RE: T&G Parker Short Plat (SP-07-131)

The Kittitas County Community Development Services Department has determined that the T&G Parker Short Plat (SP-07-131) is a complete application and hereby grants **conditional preliminary approval** subject to the following conditions:

SUBJECT: T&G Parker Short Plat SP-07-131

**K.C.S.P. NO. 07-XX**  
 Portion of the SE1/4, Sec. 31 T.19N., R.18E., W.M.  
 Kittitas County, Washington

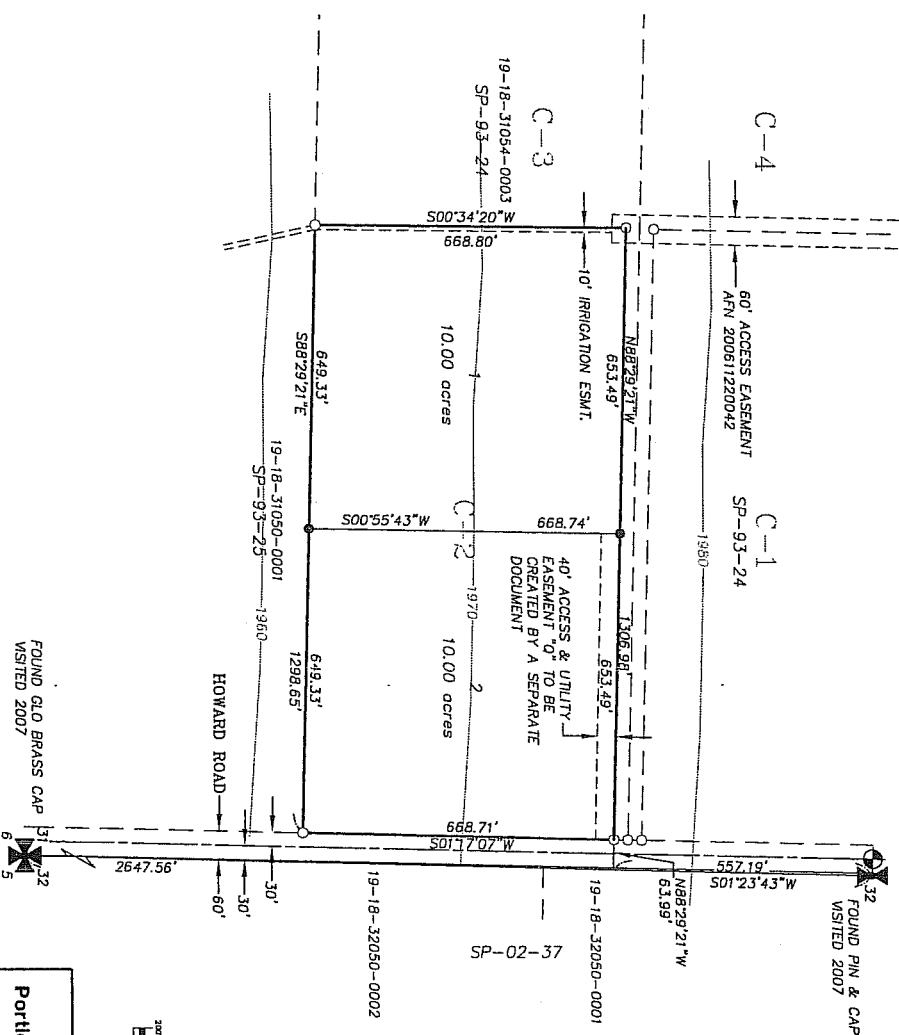
1. Both sheets of the final mylars shall reflect short plat number SP-07-131 and an accurate legal description shall be shown on the face of the final plat.

2. Access: Access to Lots 1 and 2 shall be limited to Back Country Drive and the easement leading from Back Country Drive to the northwest corner of Lot 1.

4. Back Country Drive and Easement: The entire access shall be depicted on the final plat to the intersection with Howard Road. Back Country Drive may be shown in the vicinity map.

5. Cul-de-Sac: A cul-de-sac is required at the end of the easement. Deadend streets serving three or more lots must have a cul-de-sac turnaround with an easement diameter of at least 110' (55' radius) and a roadway surface diameter of 96' at the closed end. See Kittitas County Road Standards, 9/6/05 edition.
